RE: ENVIRONMENTAL ASSESSMENT FOR MP 11_0046 - STAGE 3, 61 MOBBS LANE, EPPING.

ATTACHMENT A

DRAWING TITLE: LOWER GROUND 2	PROJECT NO:	DATE:	DRAWING No:	REV:
	697	MAY 2012		
	DRAWN BY:	SCALE:		
	GO	As indicated	A0001	1
	CAD FILE:

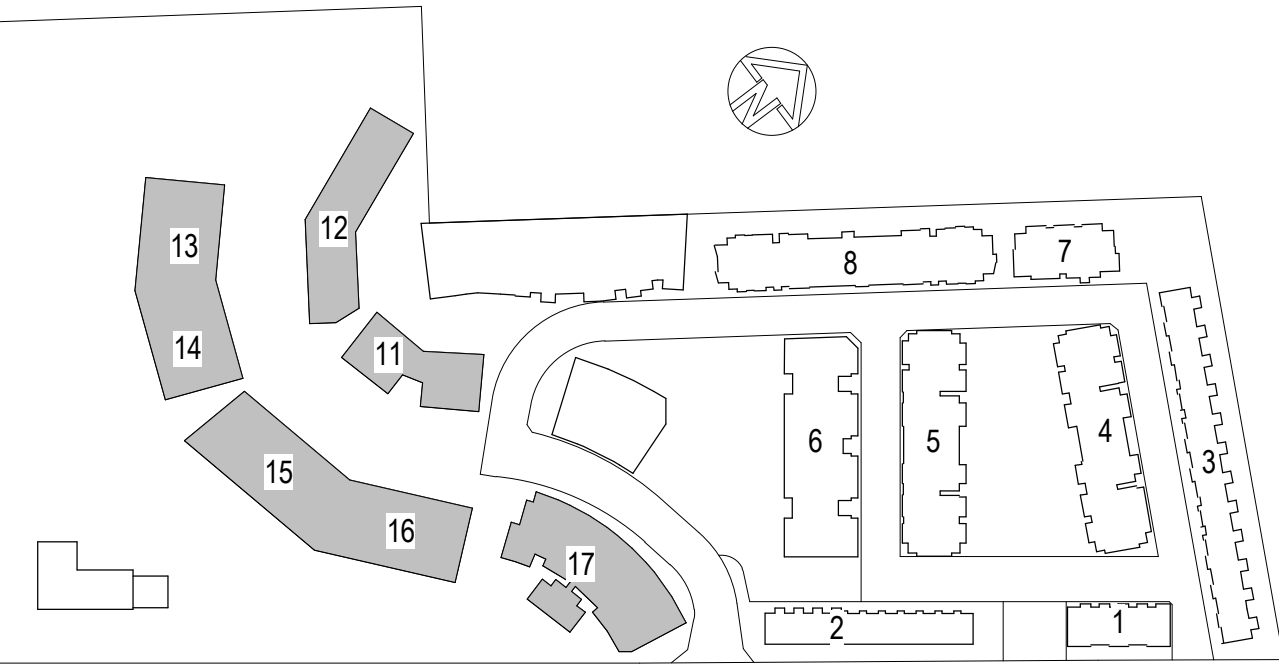
Concern is raised that the basement servicing Buildings 11-16 is too large and will result in the following problems in operation;

- a. The size of the basement to be served by only 1 internal ramp and 1 exit driveway is likely lead to congestion and queuing at the ramps and at the exit driveway in peak use periods such as morning peak hour.

- b. The proximity of the internal ramp to the exit ramp is likely to lead to conflict if cars are queuing to exit the driveway which would prevent users at the lower level from using the ramp.

- c. The use of such a large basement with only one entrance and exit would lead to confusion for visitors who would have difficulty finding both the visitor parking spaces and the correct lift core to access the building desired.

- d. The length and number of dead-end access aisles within the basement is inappropriate, particularly where visitor spaces are located in the dead-end aisle and is likely to lead to cars having to reverse back along the aisle if the visitor spaces are occupied. An example of this is the visitor spaces in proximity to Lobby 16.

- e. The number of tandem parking spaces is excessive and indicative of a poor car park layout.
- f. The location of wash bays adjacent to resident spaces is inappropriate as the cars parked in the adjacent spaces are likely to be frequently splashed by water from the car washing process. These spaces should be adjacent to visitor spaces.

SITE SECTIONS - 1

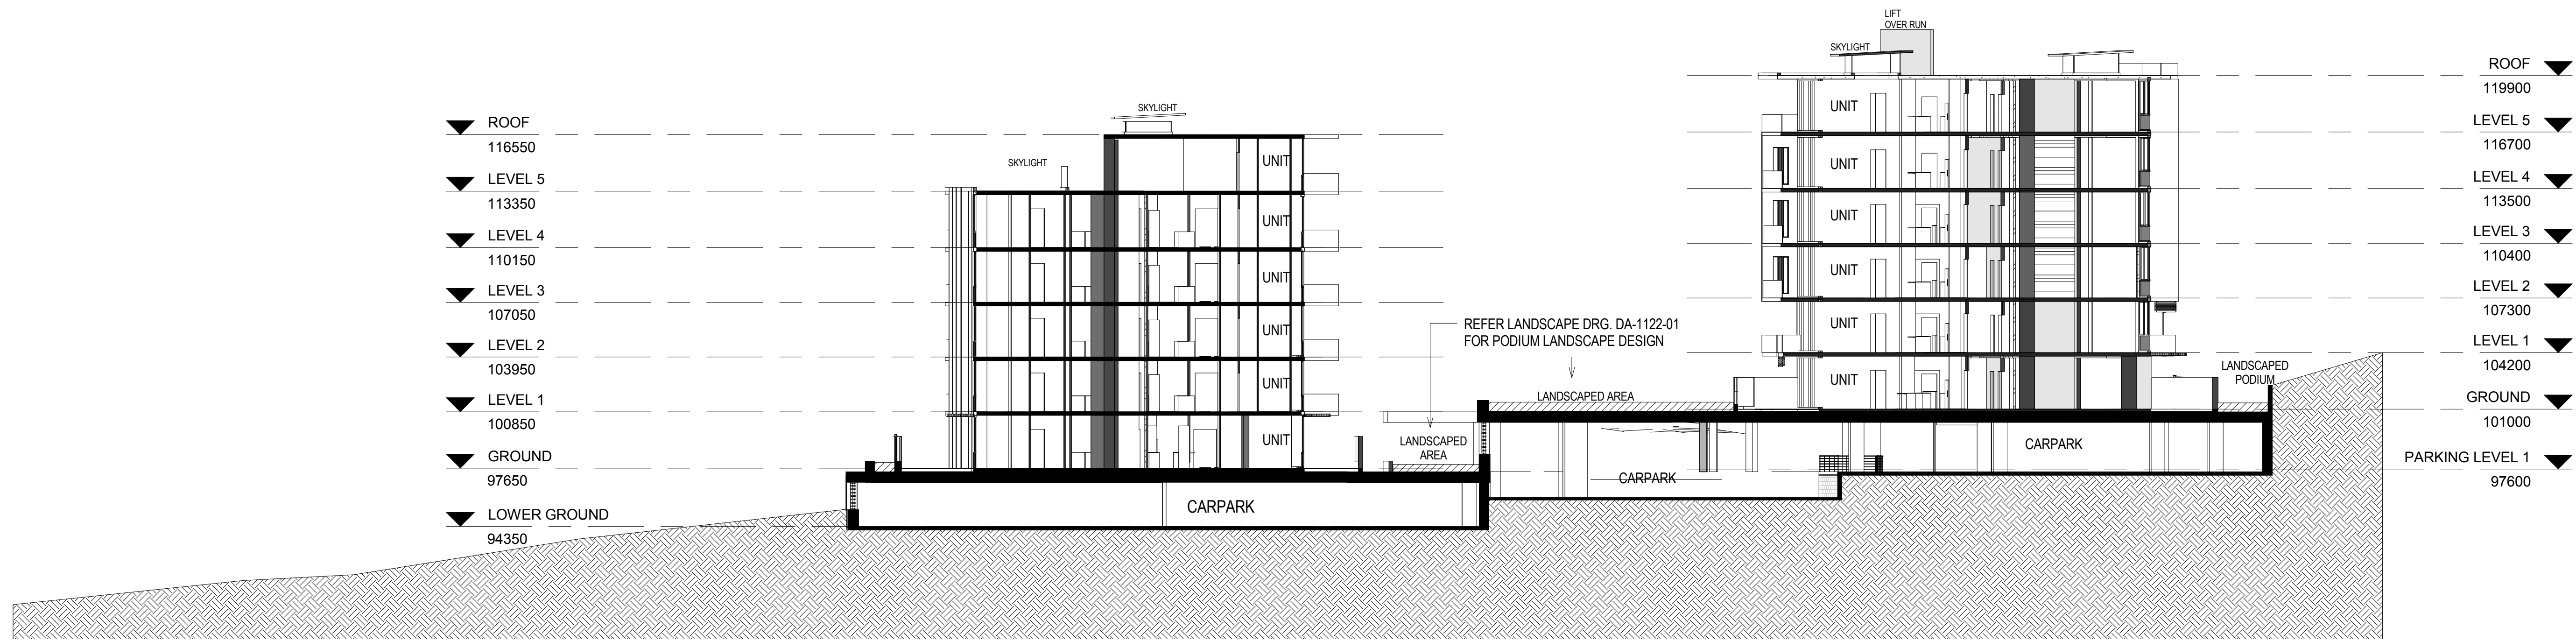
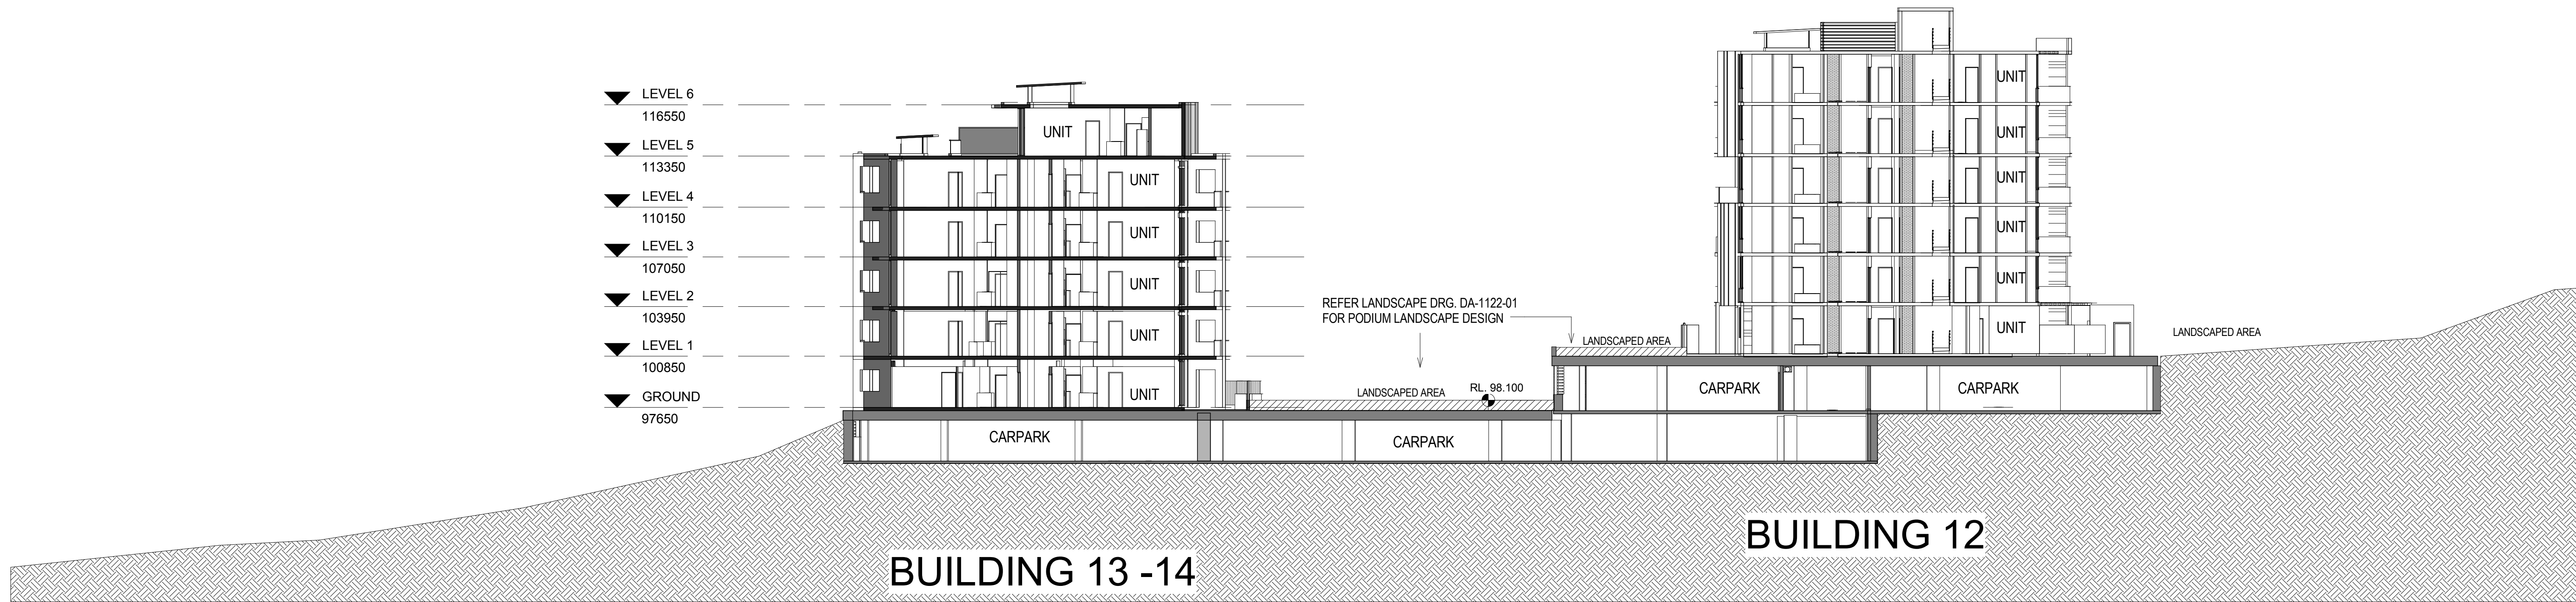
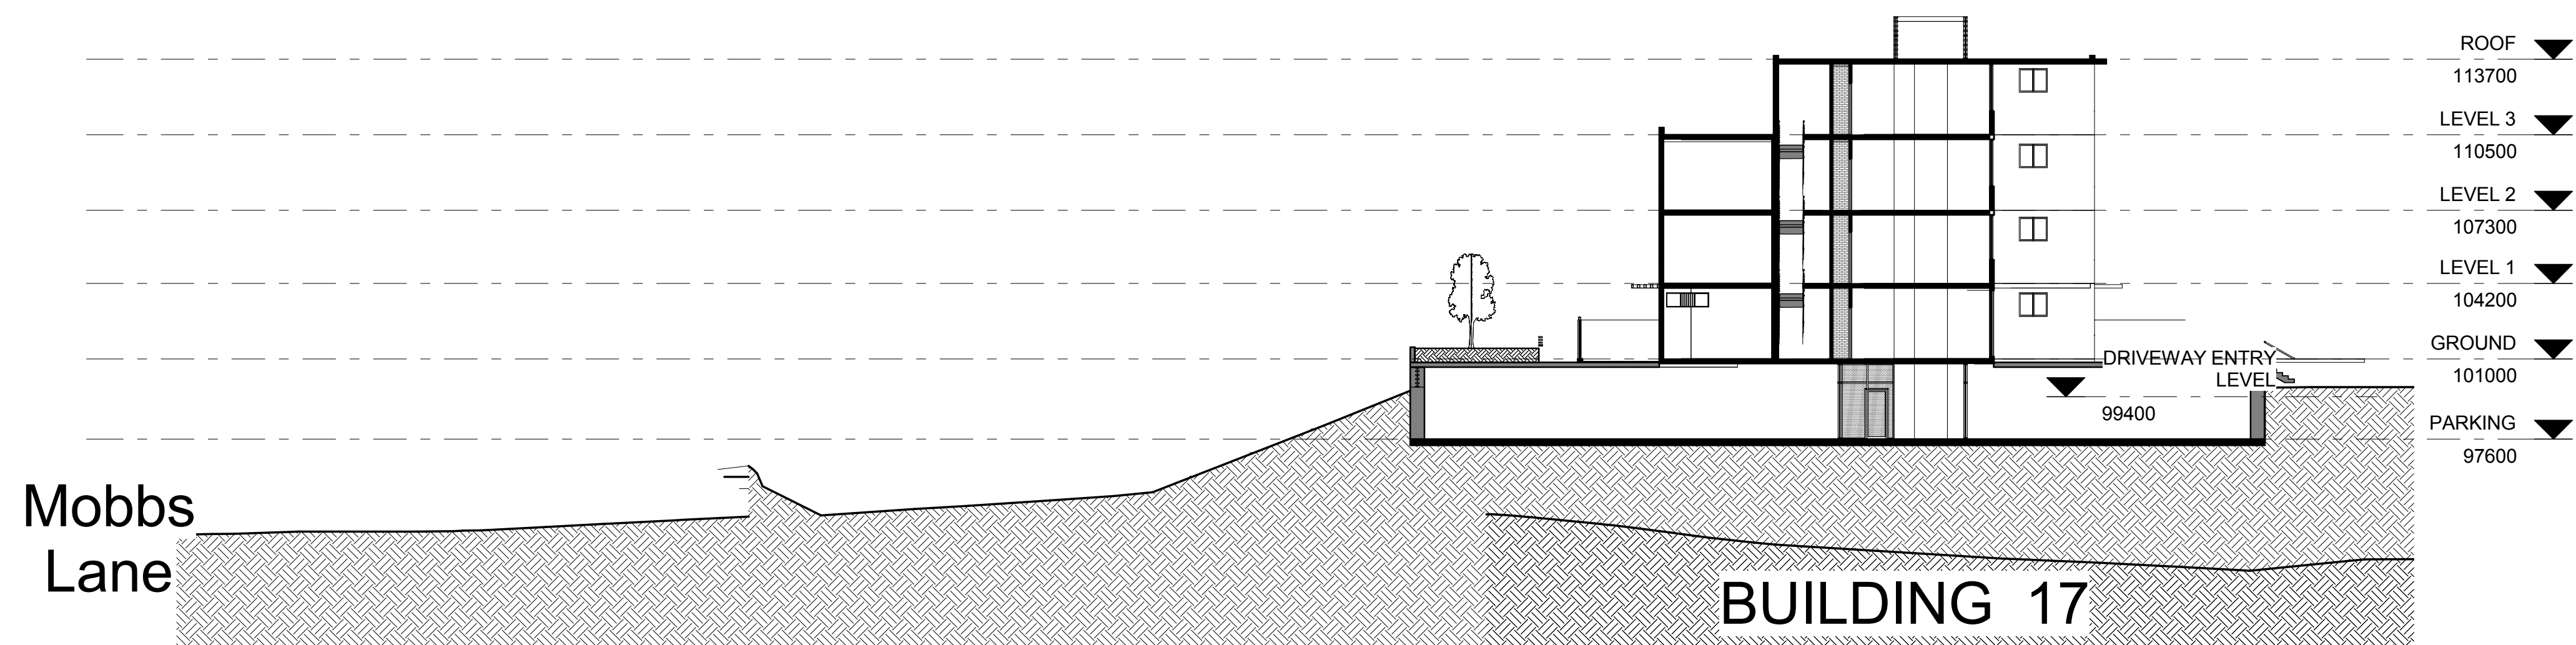
- f. No plans have been provided that show the finished levels and treatment of the podium areas.
- g. A section should be provided through buildings 11 and 15/6 and another through buildings 12 and 13/14 to allow an understanding the how the parking, podiums, buildings and topography relate. These sections are to identify the original ground level (prior to any early works) and the finished ground level after the early works.

SITE ELEVATIONS

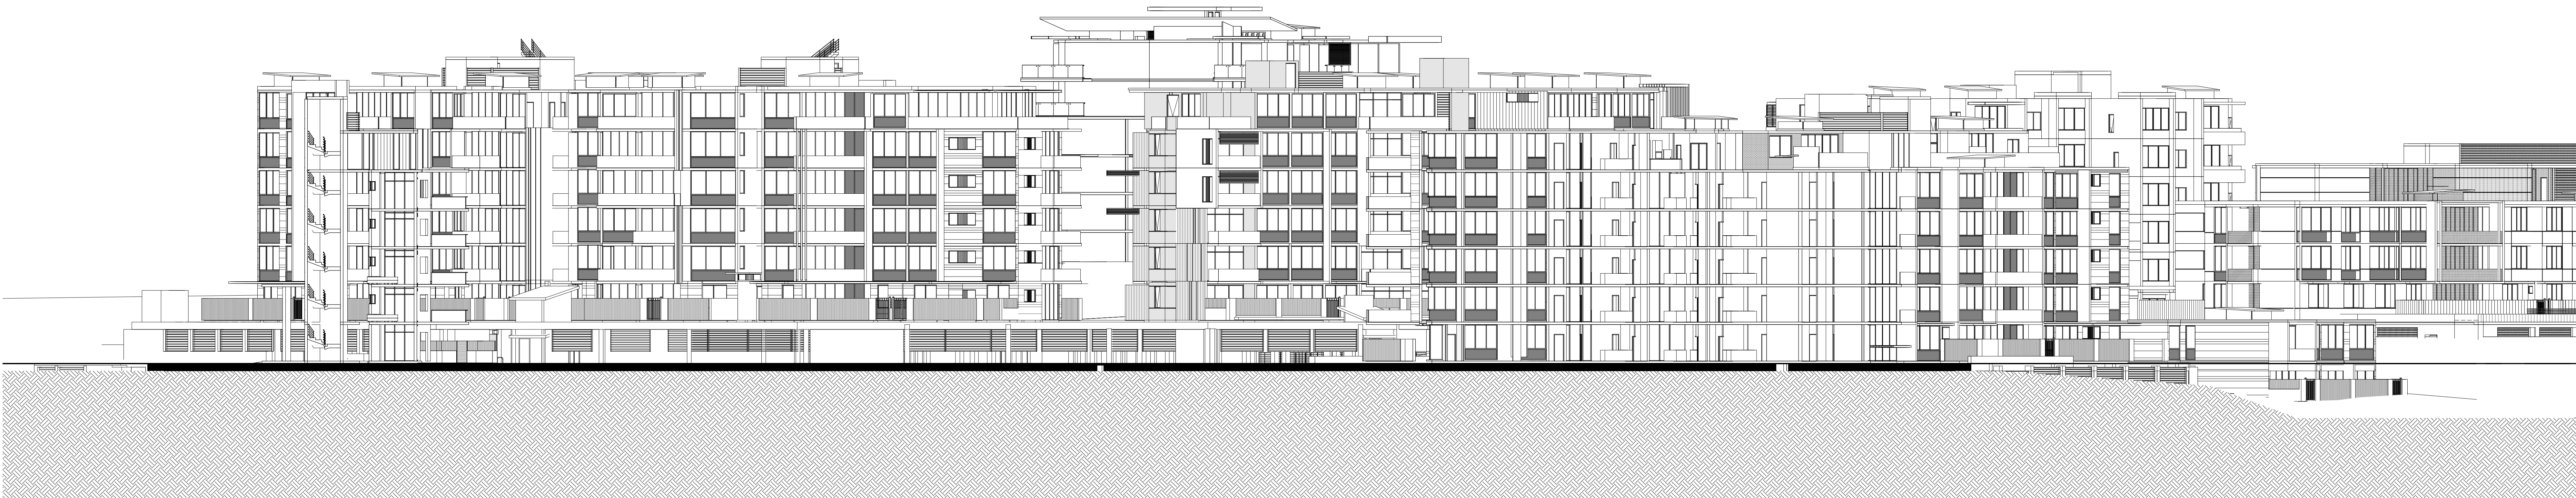
- d. No plans are provided which show the site as a whole to understand the interrelationship between the buildings and the basement parking.
- e. No elevations are provided which show the interrelationship between the buildings and the topography of the site. As a minimum an elevation as viewed from Mobbs Lane, the south-west boundary, the north-west boundary and the internal road should be provided.

client: MERITON APARTMENTS  
**EPPING PARK STAGE 3  
BUILDING 17  
LANDSCAPE PLAN**

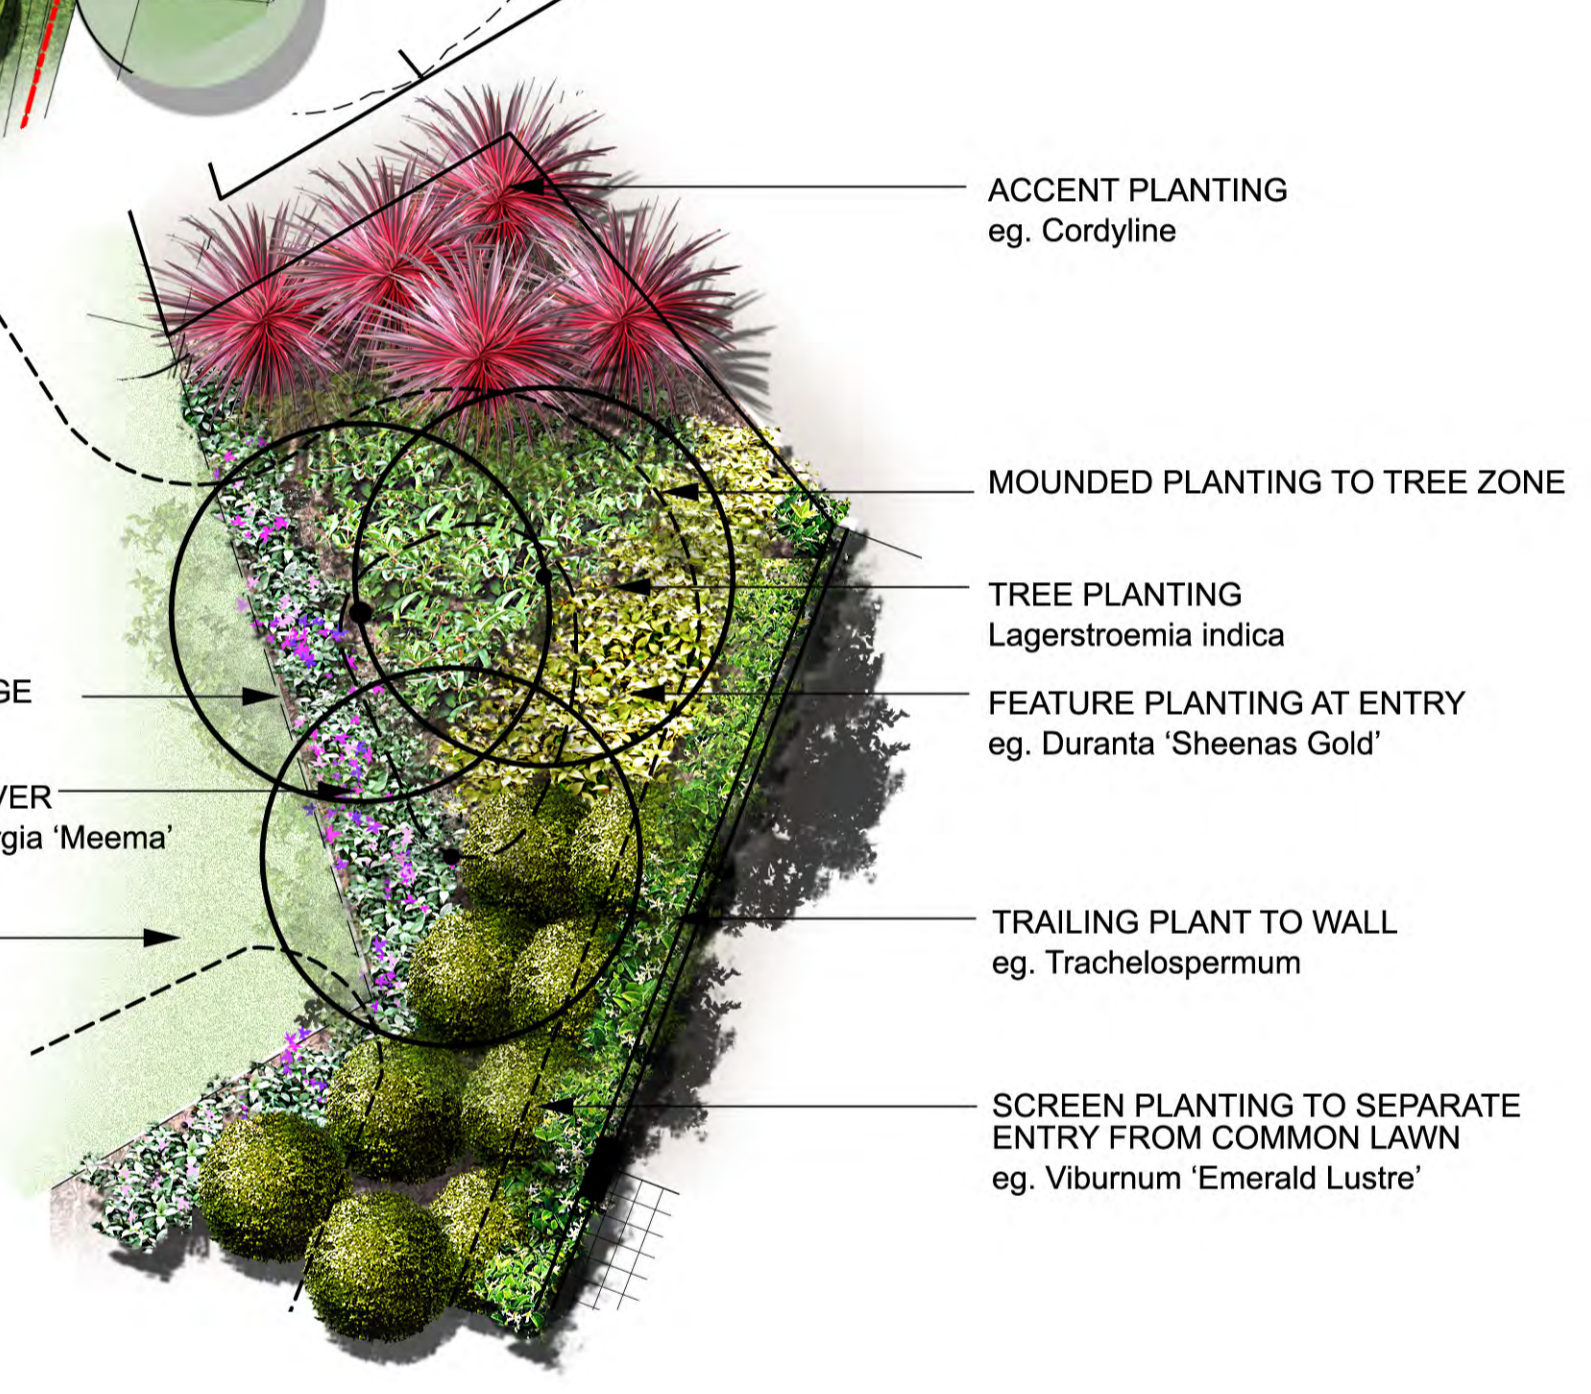
- h. A comprehensive concept landscape plan is to be provided for the grounds and podiums of Stage 3. This concept plan is to identify:
 - i) existing vegetation to be retained,

- ii) planted areas and their treatments,
 - iii) pathways between buildings,
 - iv) pathways to the footpath and within the landscaped areas,
 - v) locations for street furniture,

- vi) delineations between private, communal and publicly accessible open space;
 - vii) provide area calculations for publicly accessible open space;
 - viii) provide a typical species selection; and

- ix) show the interrelationship with the approved landscaping on the other stages.
